Ridges at Lorson Ranch
Traffic Impact Analysis
(LSC #S214080)
April 6, 2021

Engineering Review

EPC Planning & Community
Development Department

FUTURE MERIDIAN ROAD

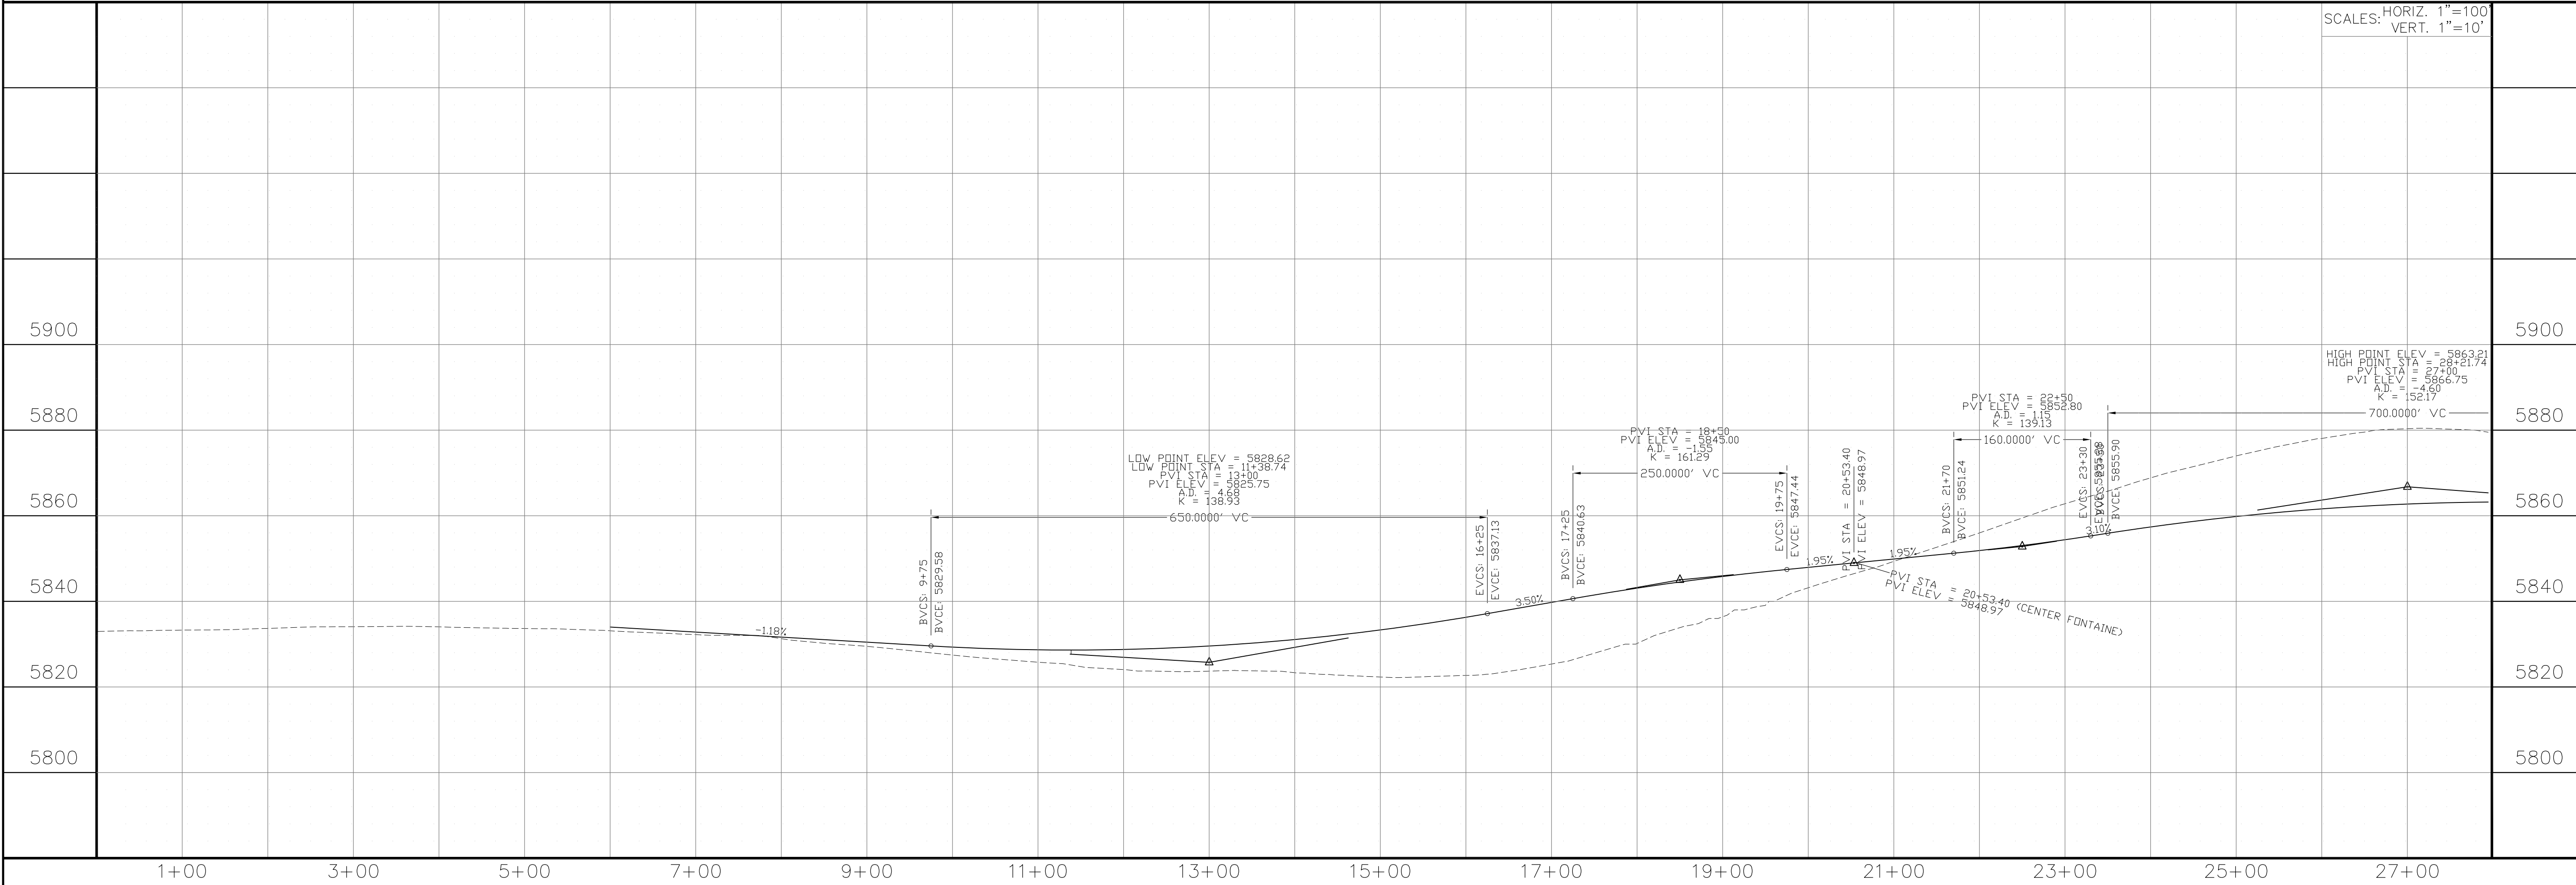
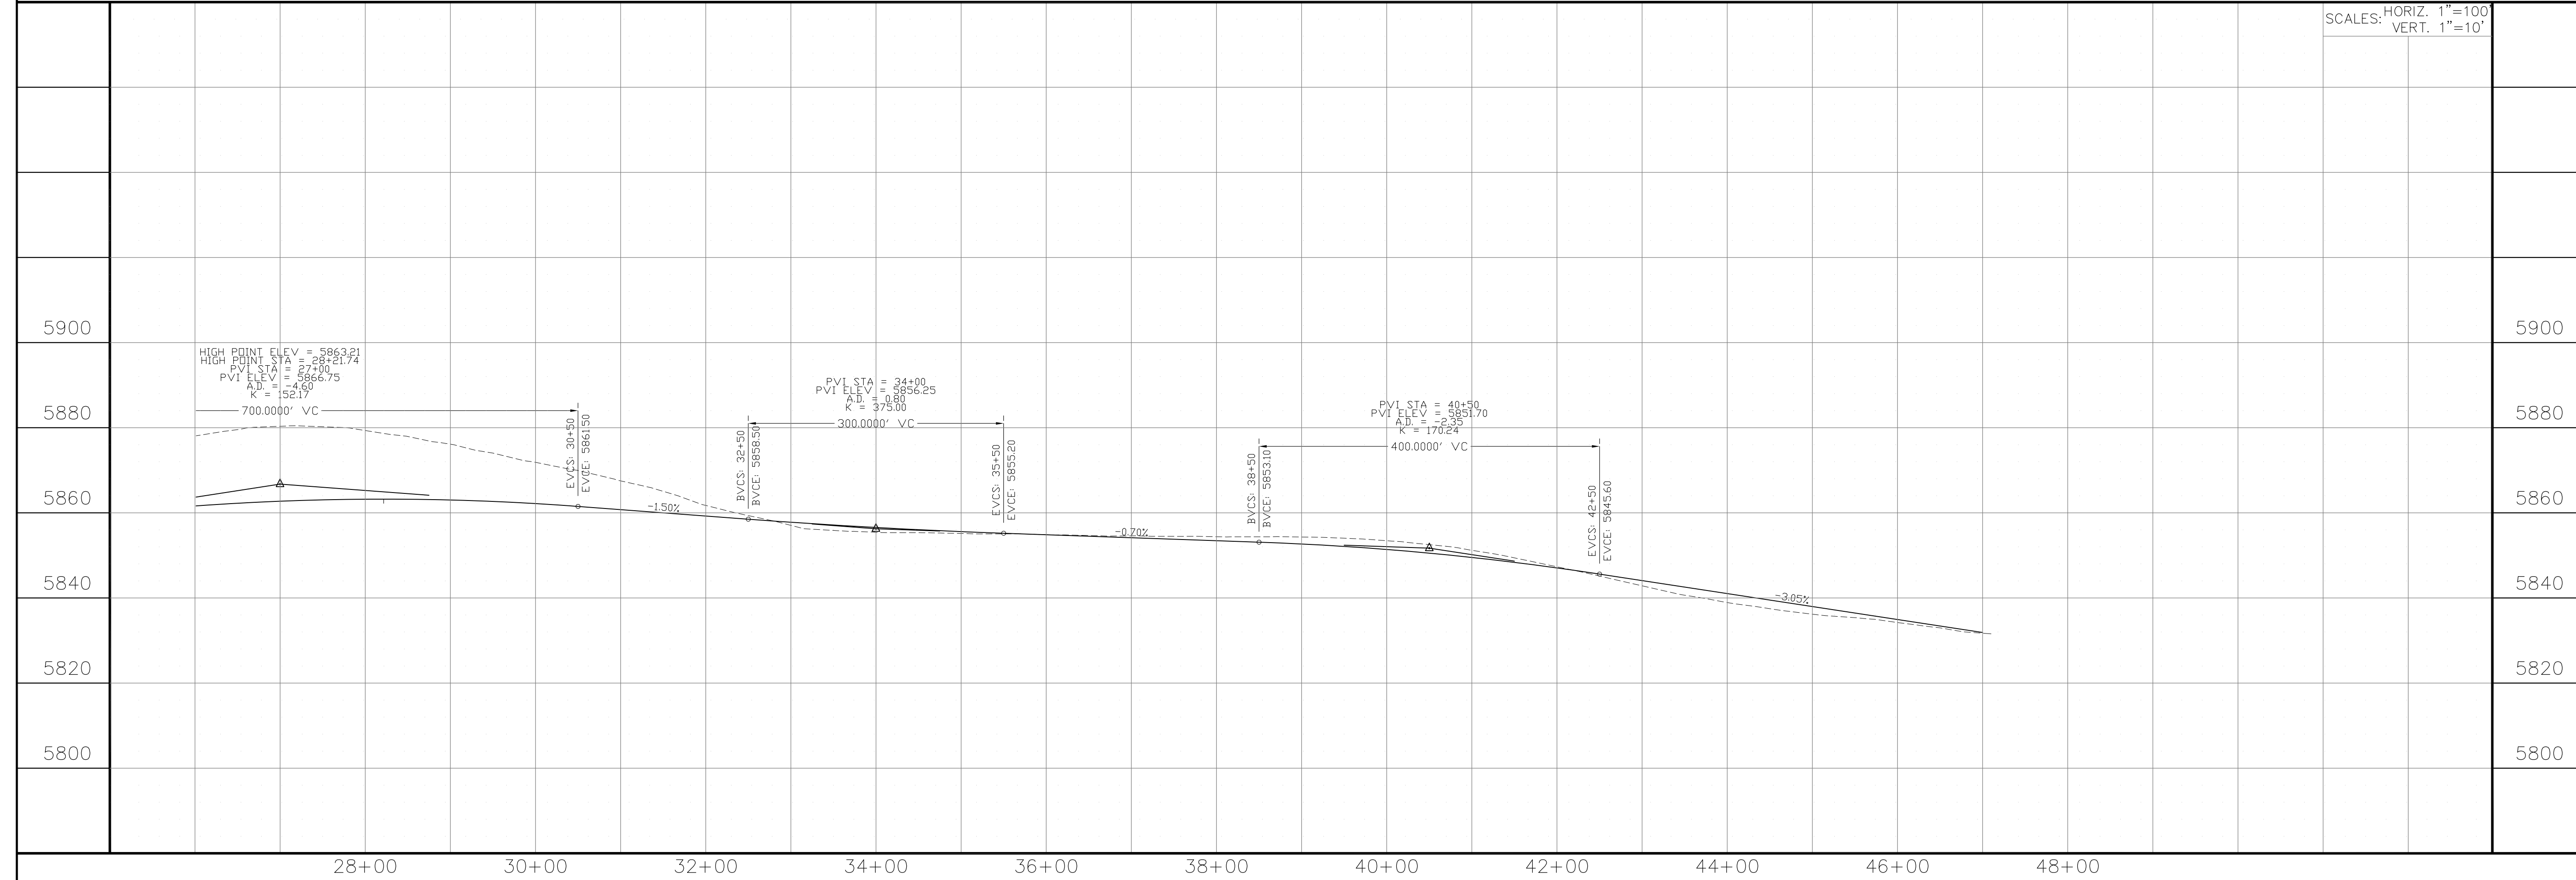
Address future Meridian Road.

Exhibit 1
Deviation Request Location
Ridges at Lorson Ranch (LSC #S214080)

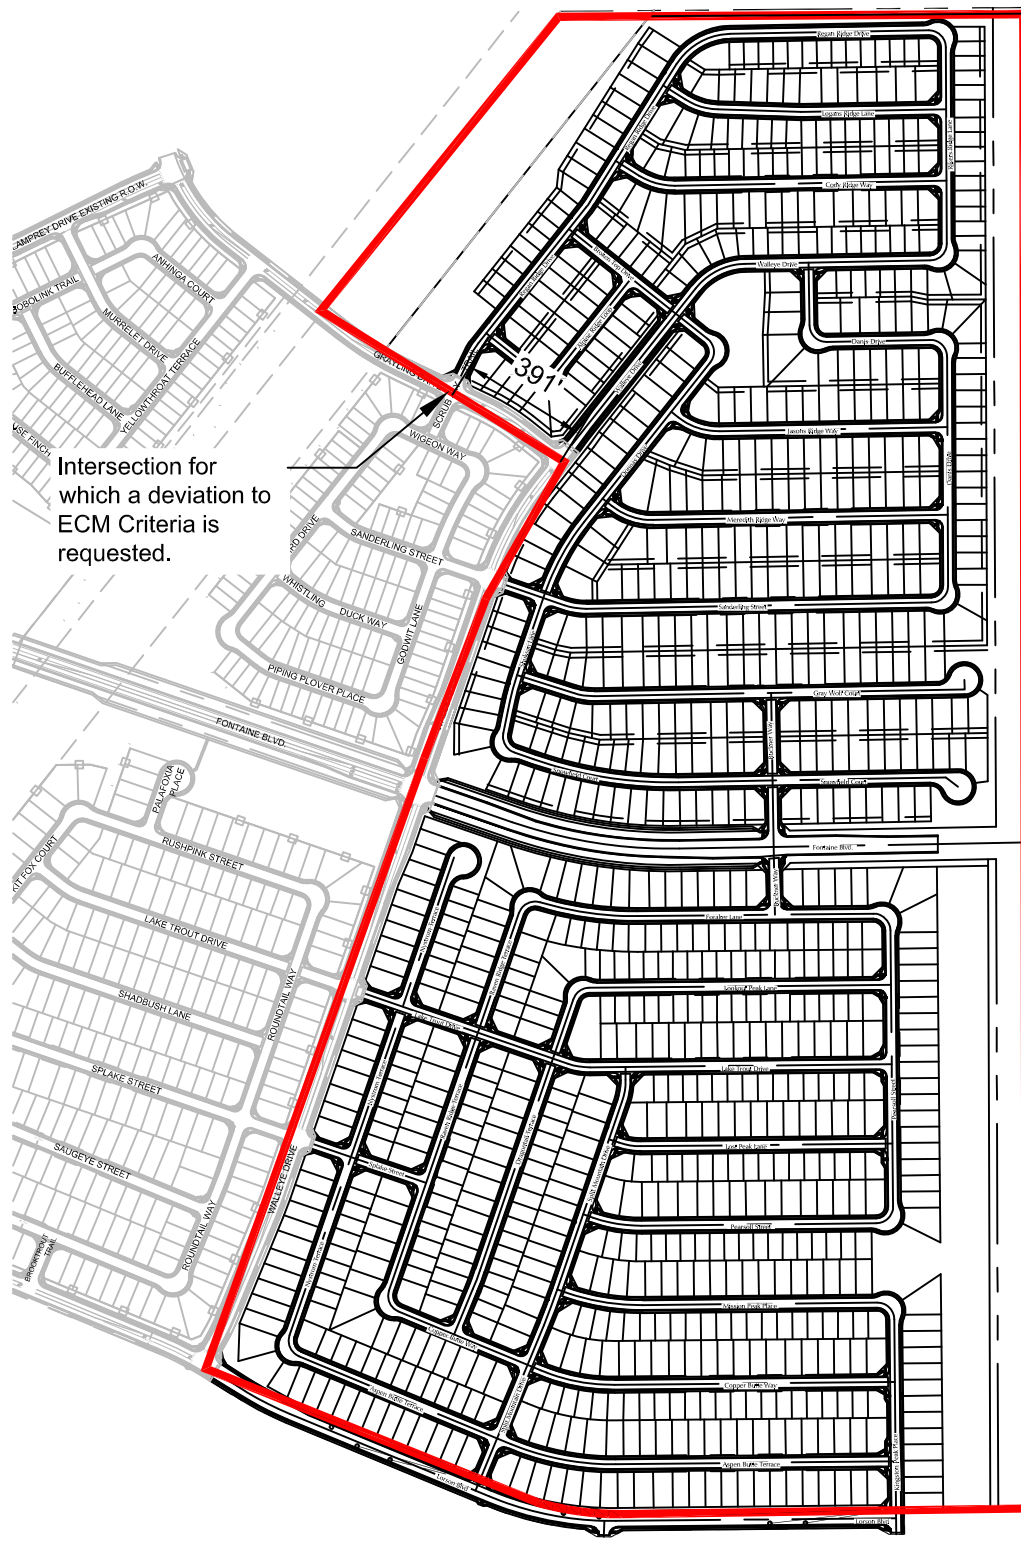
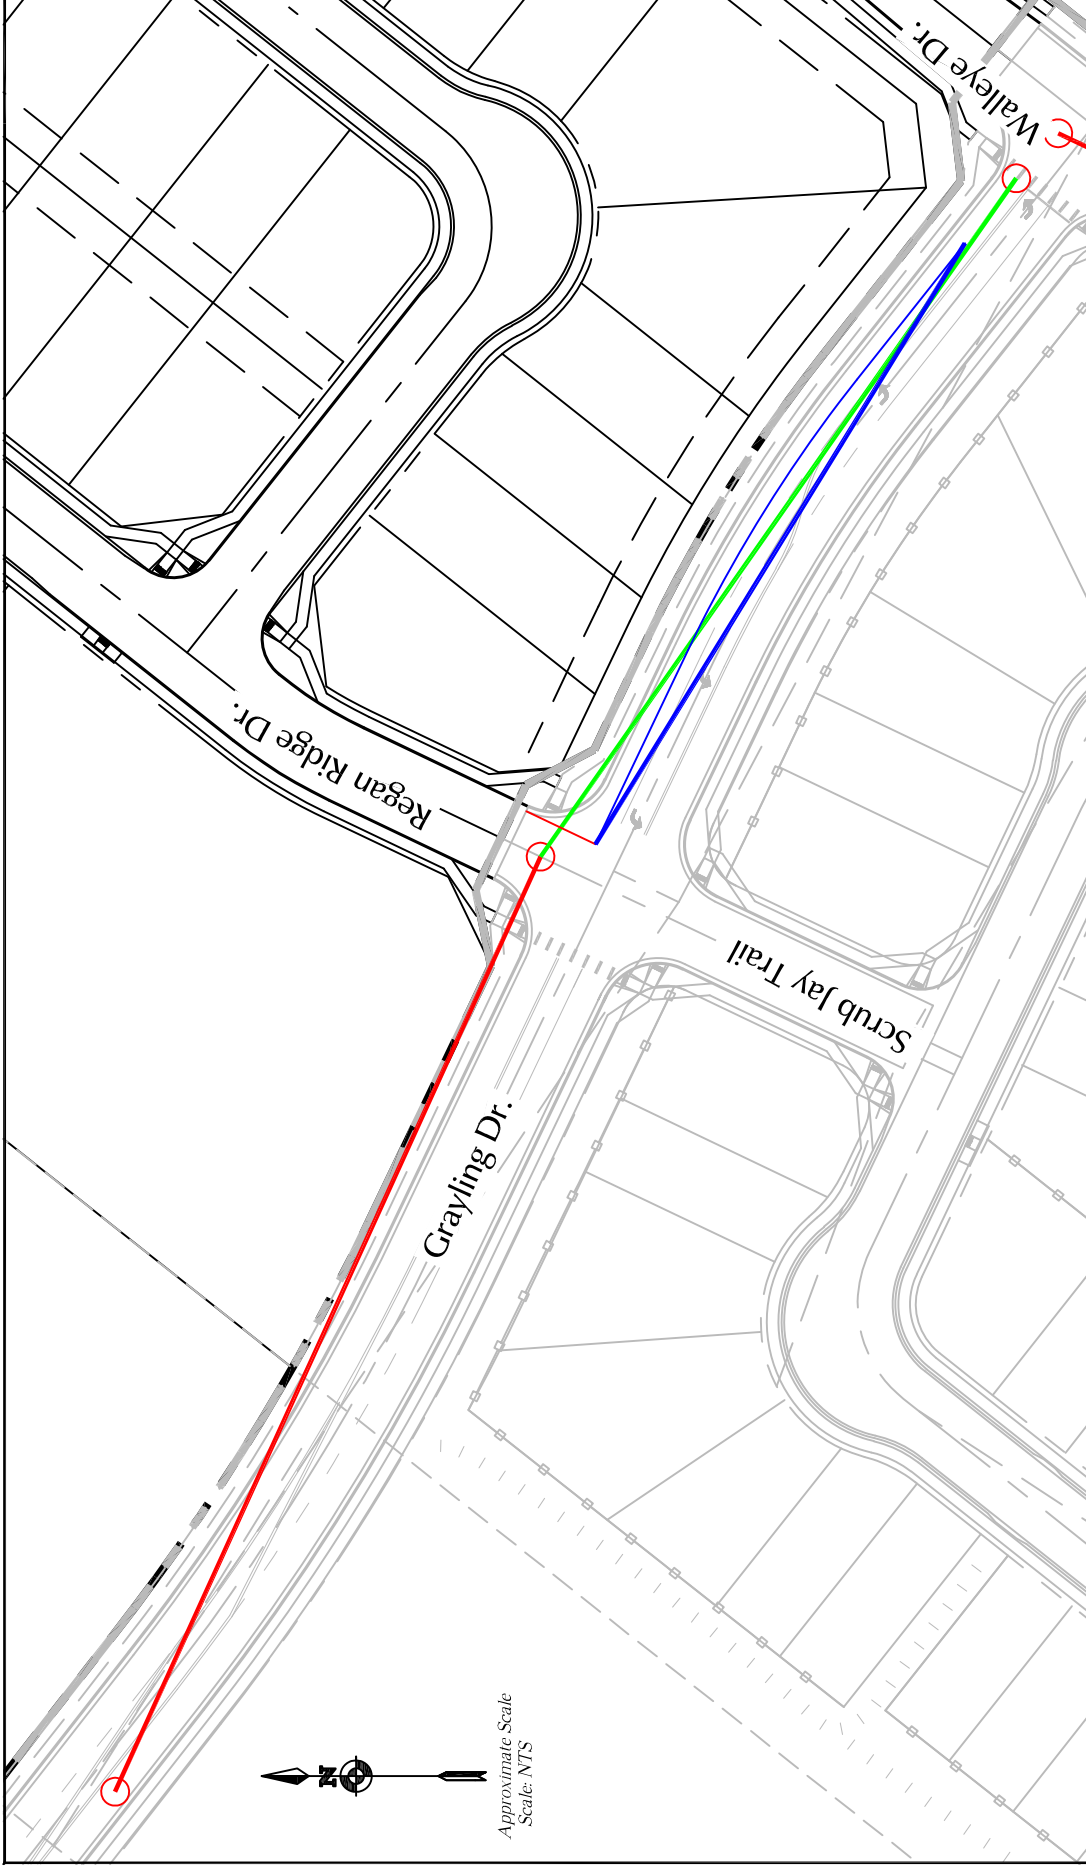
Per the Engineering Criteria Manual (ECM), the applicant will need to submit a Deviation Request for any substandard conditions. The traffic report seems to suggest that this condition may be mitigated by westbound traffic going slower than the presumed 40 MPH design speed, having just turned onto Grayling at Walleye Drive. A firm recommendation on mitigation would help justify the Deviation Request.
